A38 Derby Junctions
TR010022
8.x Statement of Common Ground with
Euro Garages Ltd

**A38 Derby Junctions
Development Consent Order 202[]**

**Statement of Common Ground
Euro Garages Ltd**

Drawing Title  
FIGURE 2.6  
MARKEATON JUNCTION  
GENERAL ARRANGEMENT

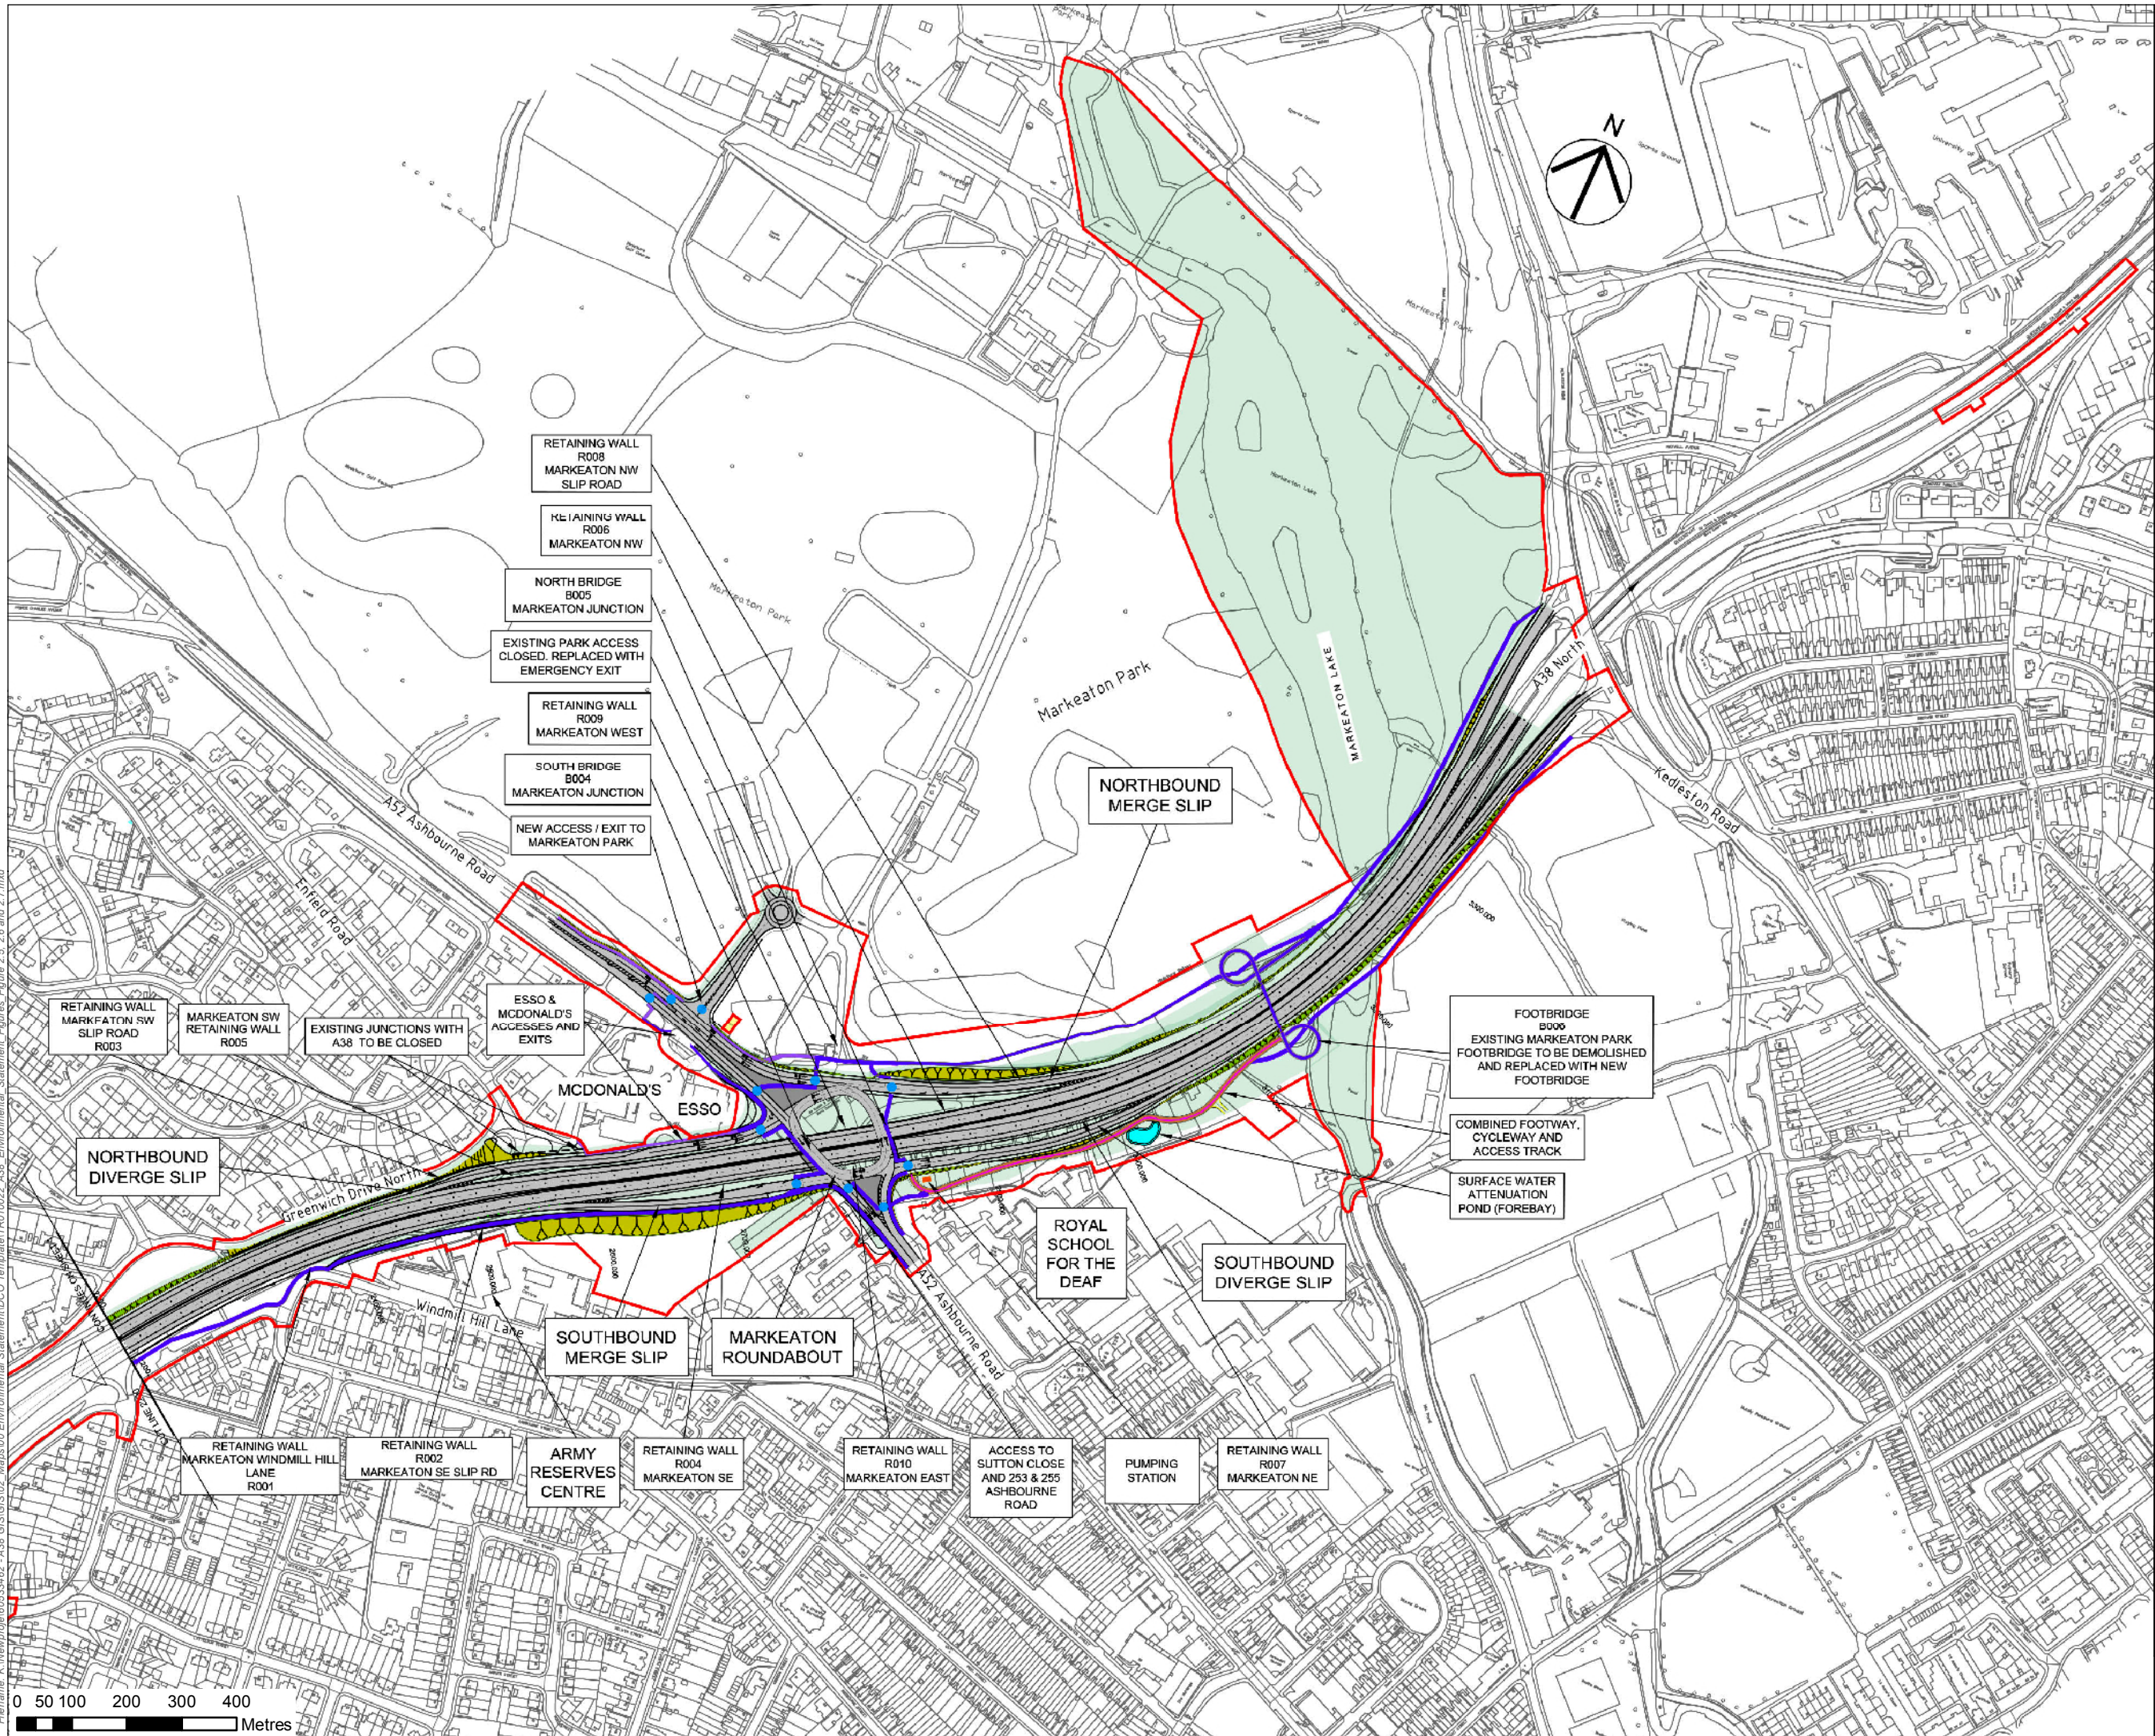
Issue reference (see Appendix A)	Document	Paragraph Ref	Sub-section	Comment	Highways England Response	Status
				Highways England has yet to determine whether such signage could be provided.		
Issue ref: I.1, access and safety	Written Representation Comments	-	-	The scheme will also seriously reduce the accessibility to the site for traffic that continues to use the junction through interference with existing access arrangements, including works of stopping up and modification of accesses. We have further concerns over the Scheme in relation to the access arrangements that are currently proposed within the Scheme, in substitution of the existing access arrangements, because of their adverse effect on essential safe fuel delivery arrangements and access for HGV traffic.	The site will continue to enjoy entry and exit arrangements with the A52. The existing entry and exit arrangements with the A38 are to be modified to exit only (onto the proposed A38 slip road) for safety reasons. It is envisaged that fuel delivery will continue as it does at present, i.e. the tanker will enter the site from the A52 and will leave the site onto the A38 slip road.	Under discussion

Issue ref: I.1, access and	Written Representation Comments	-	-	Additionally, Euro Garages Ltd property currently enjoys direct and satisfactory access to the public highways of both the A38	Currently it is necessary to cross land owned by McDonald's to gain access to the filling station from both the A38 and the A52.	Under discussion

Issue reference (see Appendix A)	Document	Paragraph Ref	Sub-section	Comment	Highways England Response	Status
economic impact				<p>and A52 without the need to cross land in third party ownership. Unless the orders make provision for continued direct and satisfactory accesses that would allow the effective use of the service station in commercial terms, Euro Garages Ltd property would be further and unnecessarily depreciated in value.</p> <p>Additional Comment on Highways England's Statement</p> <p>The statement that the proposed scheme will not change these existing arrangements is not accepted on the basis of the preliminary investigations that have been undertaken on behalf of Euro Garages Limited.</p> <p>These investigations, which have involved producing a draft</p>	<p>A check with the land registry confirms that there are appropriate rights, by way of a conveyance dated 1982 to allow those who need to access the filling station to cross the land owned by McDonalds which abuts the highway at any time, day or night.</p> <p>The proposed scheme will not change these existing arrangements.</p>

Issue reference (see Appendix A)	Document	Paragraph Ref	Sub-section	Comment	Highways England Response	Status
				<p>overlay plan, illustrate that the documentary rights of way referred to in Highways England's response will be interfered with as a consequence of the scheme. Whilst the detail needs to be verified through detailed site survey to check the overlays, it appears that the proposed scheme will involve access over land lying outside the existing rights of way which is not within the control of Euro Garages Limited. If detailed investigation confirms this position, the adverse consequences on the operation of the service station and the resultant depreciation in value are likely to be significant. Euro Garages Limited considers that it would be possible for Highways England to ensure that appropriate rights of way can be made available to accommodate these issues and mitigate the adverse effects of the scheme.</p>
